Application number: 2020/91978	
What is the application for?:	Part demolition of boundary wall to form new off road parking space (within a Co
Address of the site or building:	22, Town Head, Honley, Holmfirth, HD9 6BW
Postcode:	WF14 8EA

Type of comment: An objection

SITE PLAN AS PROPOSED

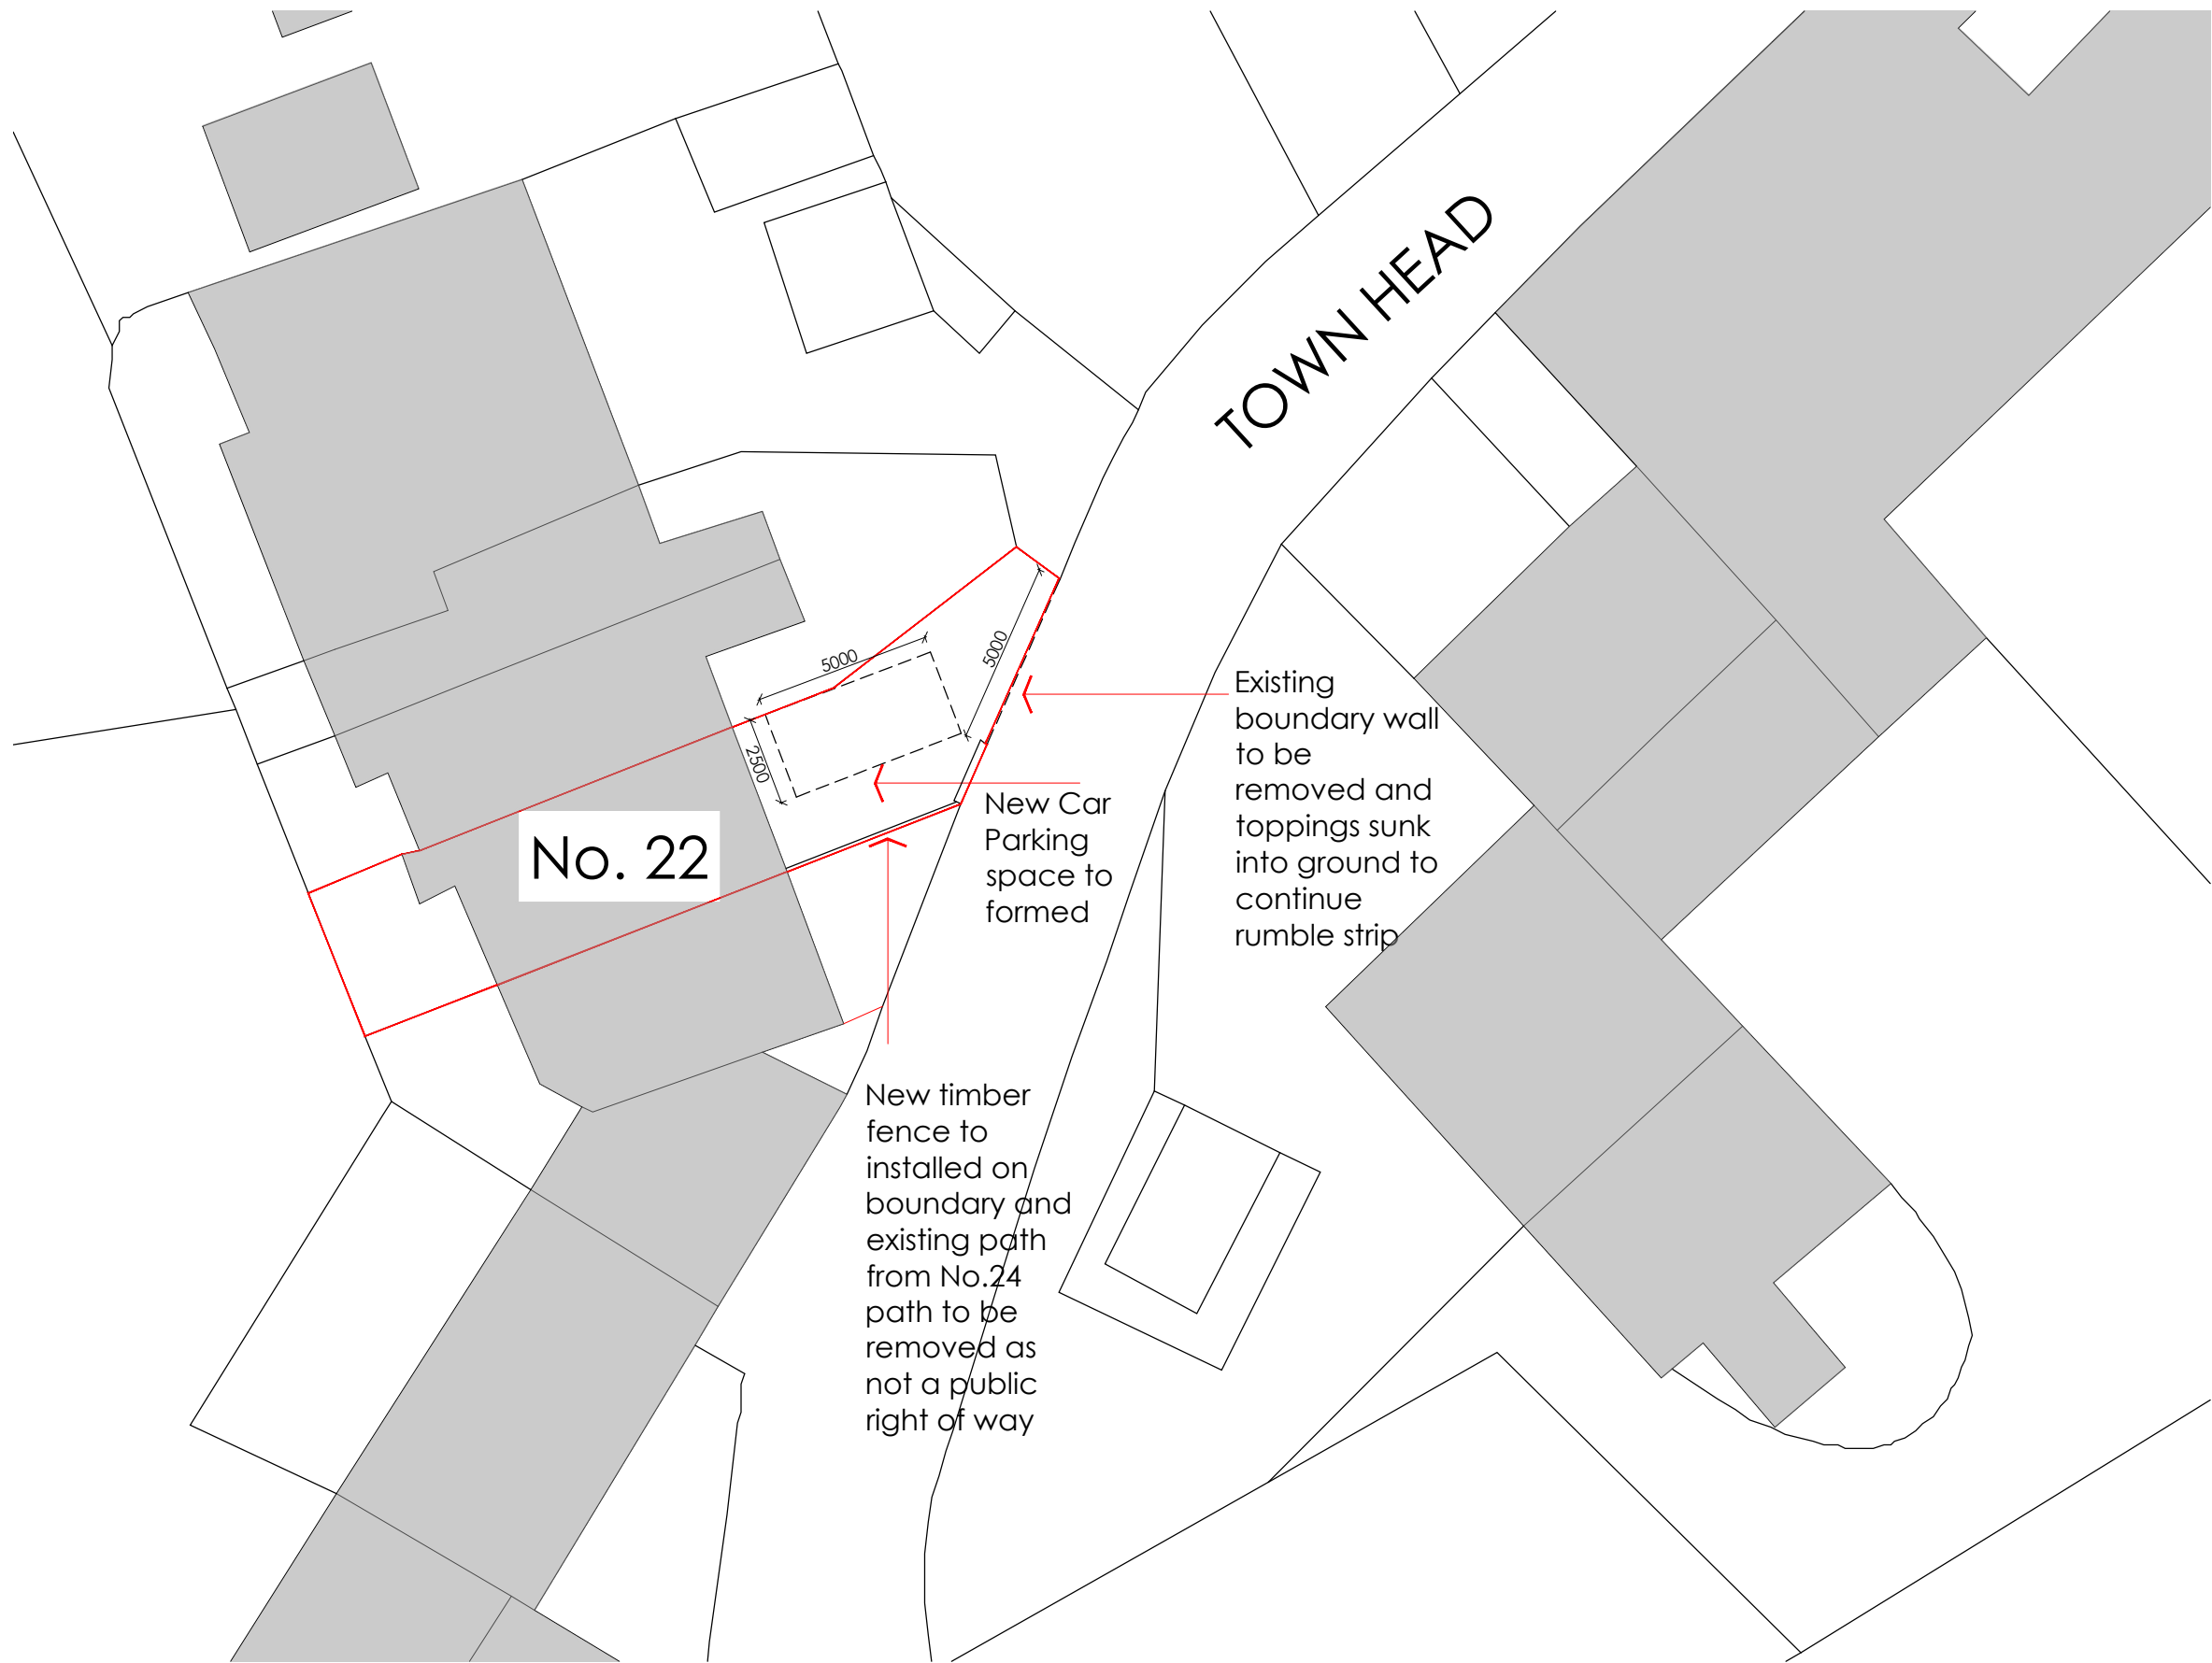
To demolish the wall for the off-road parking of one vehicle would create more issues than it would resolve. It would further impact the lack of space to manoeuvre and negotiate a very narrow street with no pavements, thus having a potential to cause accidents.

Due to the limitations of free space on the street, local residents, including those living in within the boundaries of the walled area in question, put their wheelie bins next to this party wall for refuse collection. Garden refuse bins seem to have a permanent place of residence there. If it was not possible to leave bins in situ here the residents would have no option but to look towards putting their bins outside which is unacceptable. We already have a problems with neighbours parking across thus restricting access and the removal of the wall would only further enhance the issues.

TOWNHEAD STREET SCENE_
AS PROPOSED_
Scale 1_100

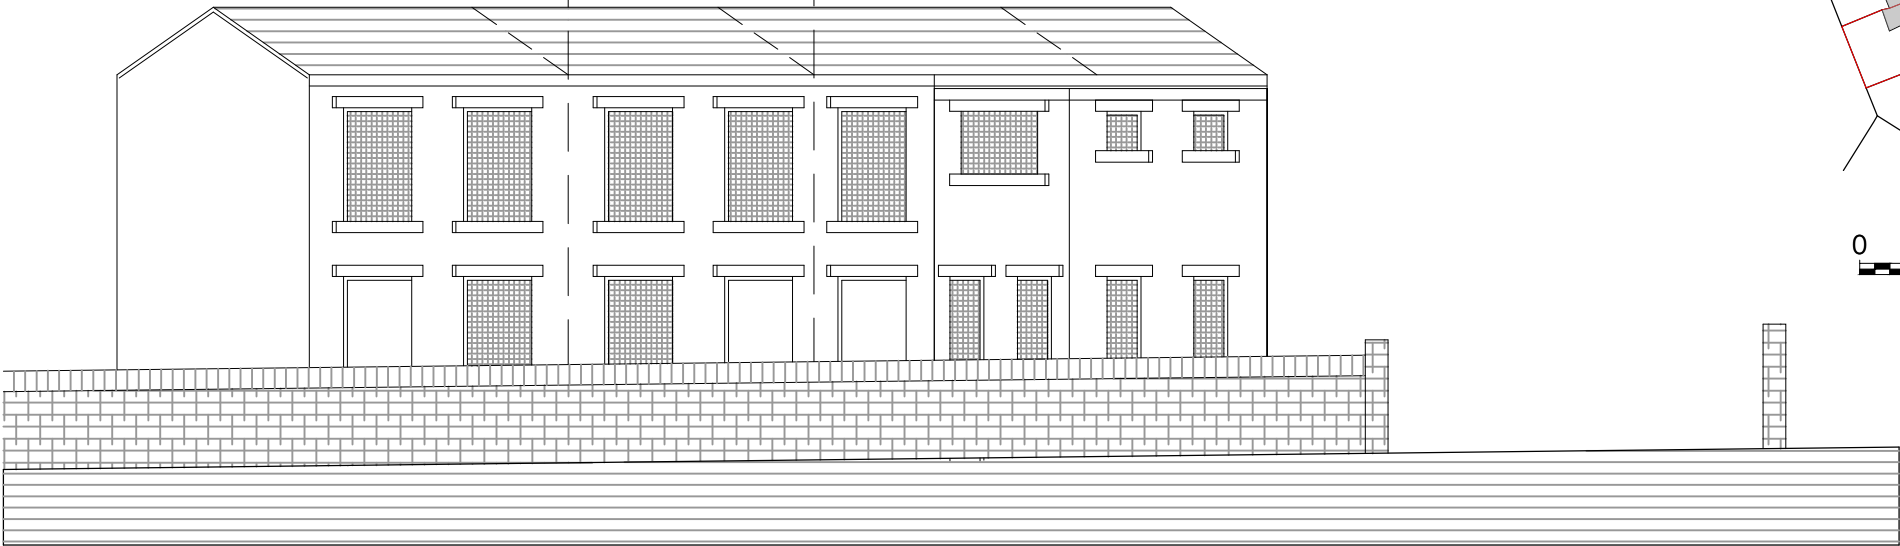
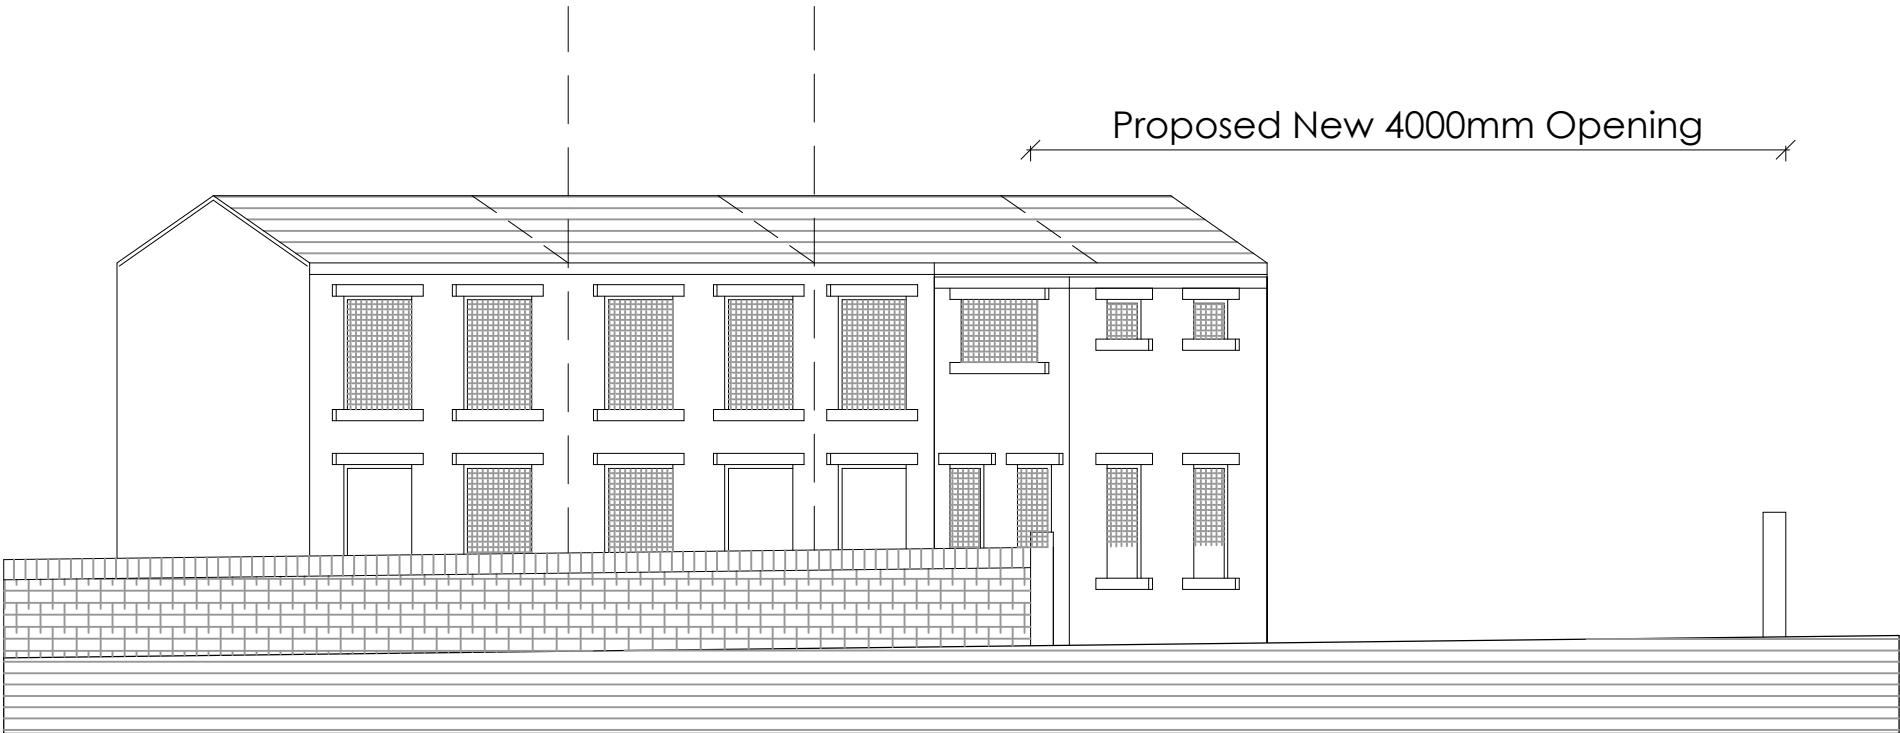
The demolition of this drystone wall will spoil the appearance and historical character of a street in what is supposed to be a conservation area. It is important we take great care in preserving the original features of our beautiful village and surrounding areas.

In conclusion we should protect our historical villages and to grant approval for the demolition of this drystone wall to create a carpark would undoubtedly spoil the appearance of the street and disrupt everyday life in what is already a tight community. We need to retain these historical walls and building such as this so we can remain living in harmony and they can be enjoyed by visitors and the streets next generations of occupants.
